From: alan.story@hertfordshire.gov.uk
Sent: 01 October 2015 10:31
To: Planning
Subject: Planning application 6/2015/1824/ADV - Land off Comet Way

District ref: 6/2015/1824/ADV
HCC ref: WH/255/2015
HCC received: 17/09/2015
Area manager: James Dale
Case officer: Alan Story

Installation of 3no illuminated fascia signs, 2no illuminated projecting signs and 8no non illuminated amenity boards

Drawing Title:  
Proposed External Signage  
elevations  
Contract Name:  
New Build  
Hatfield  
AL10 OXY

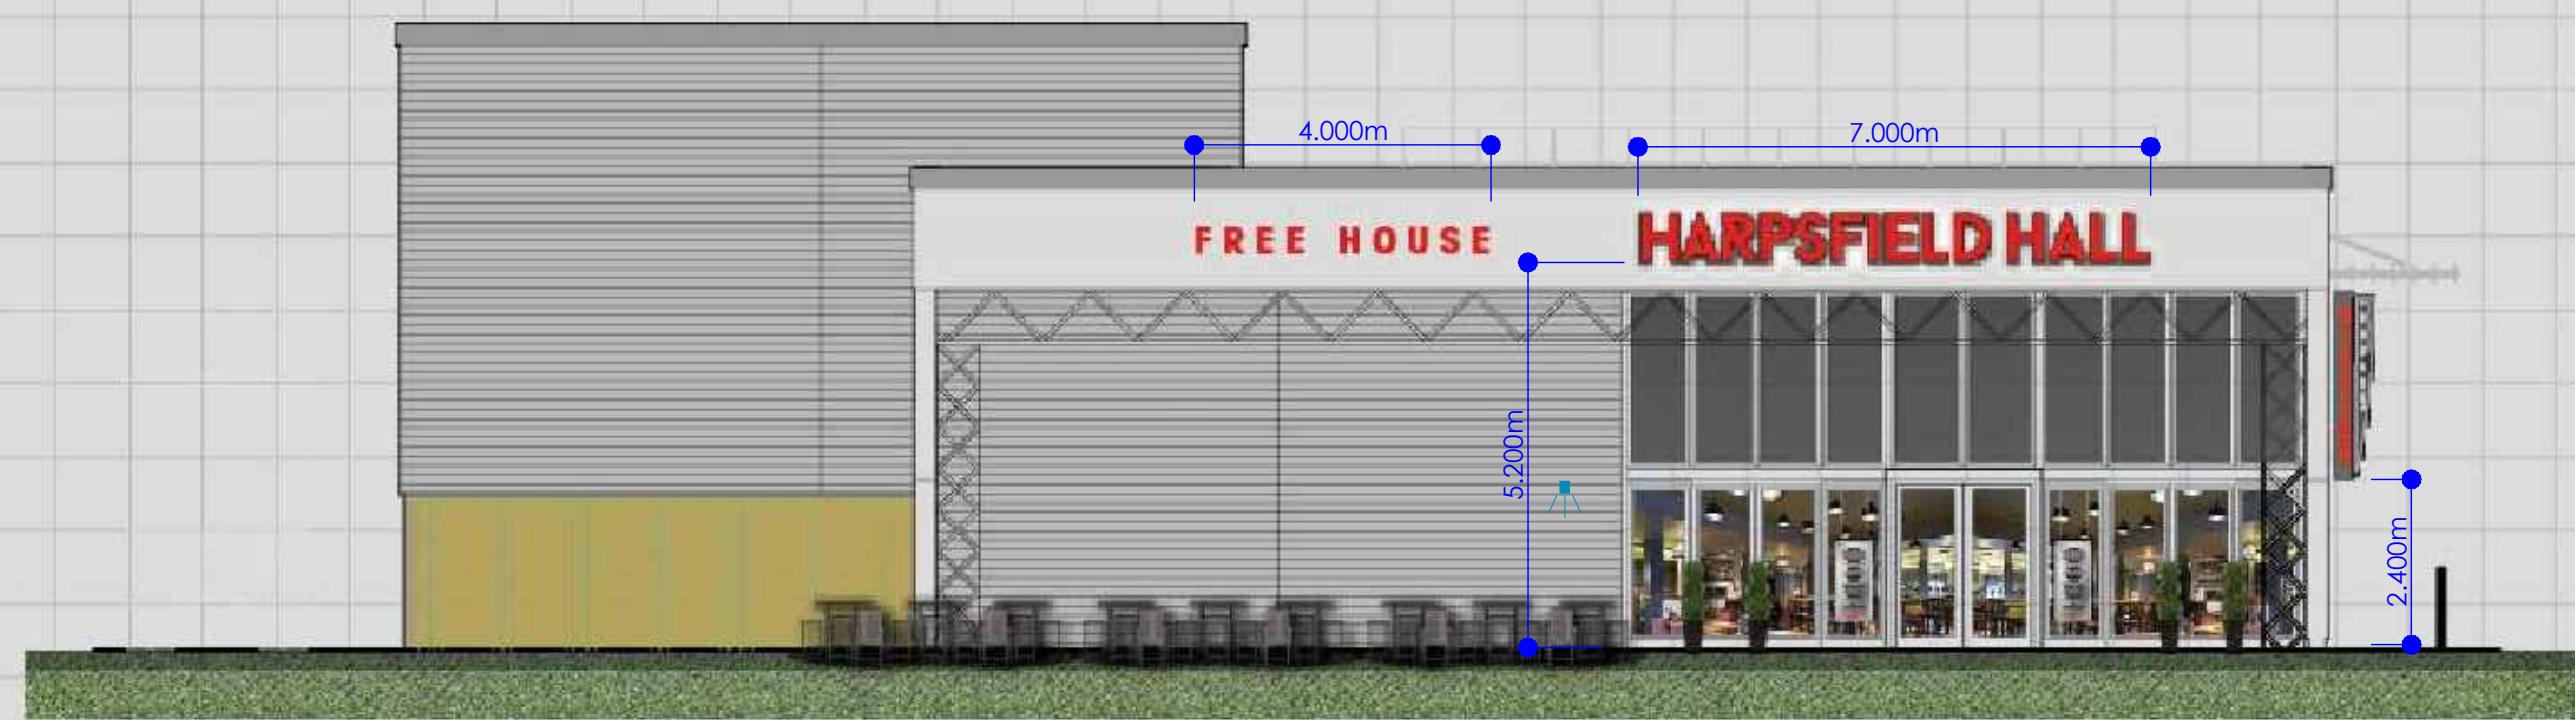
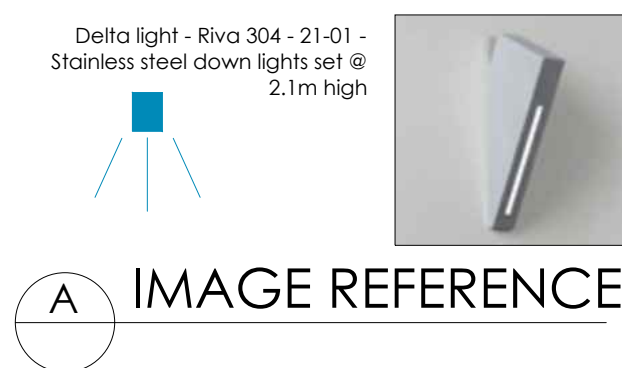
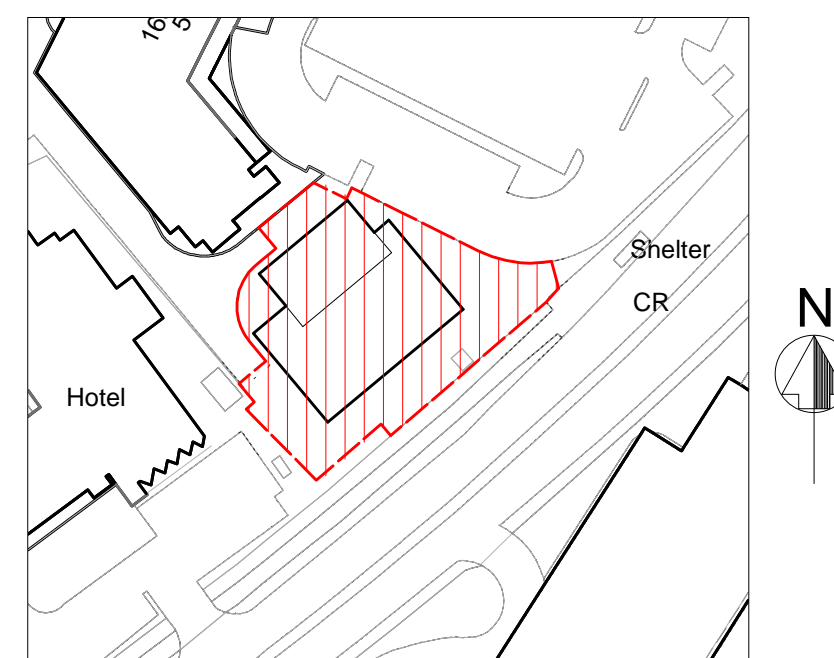
Proposed fascia signage shall be visible to vehicles approaching the site along Comet Way in both directions. The site is located opposite the Galleria which features a variety of signage, and accidents past the site are not considered attributable to distraction out of vehicle, therefore the proposed signage not considered shall represent an unacceptable distraction to driver attention. The fascia signage shall be internally lit, static in nature and described as providing a level of illuminance within acceptable standards.

Projecting signs do not oversail nor impact on the adjacent footway. The hanging signage shall be internally lit, static in nature and described as providing a level of illuminance within acceptable standards.

On the above considerations the signage shall not represent an unacceptable impact in terms of glare or dazzlement to drivers on the adjacent highway network.

The above condition is recommended to ensure that any damage to signs that might expose sources of illumination, thereby increasing risk of such glare to drivers, be repaired and maintained ensuring that the source of illumination is shrouded at all times and considered appropriate given the sensitivity of the road adjacent.

1. The means of illumination shall be shielded so that no glare or dazzle occurs to drivers of vehicles using the public highway, and such screening shall thereafter be maintained to the authority's satisfaction. Reason: To avoid glare or undue distraction to road users in the interest of road safety.
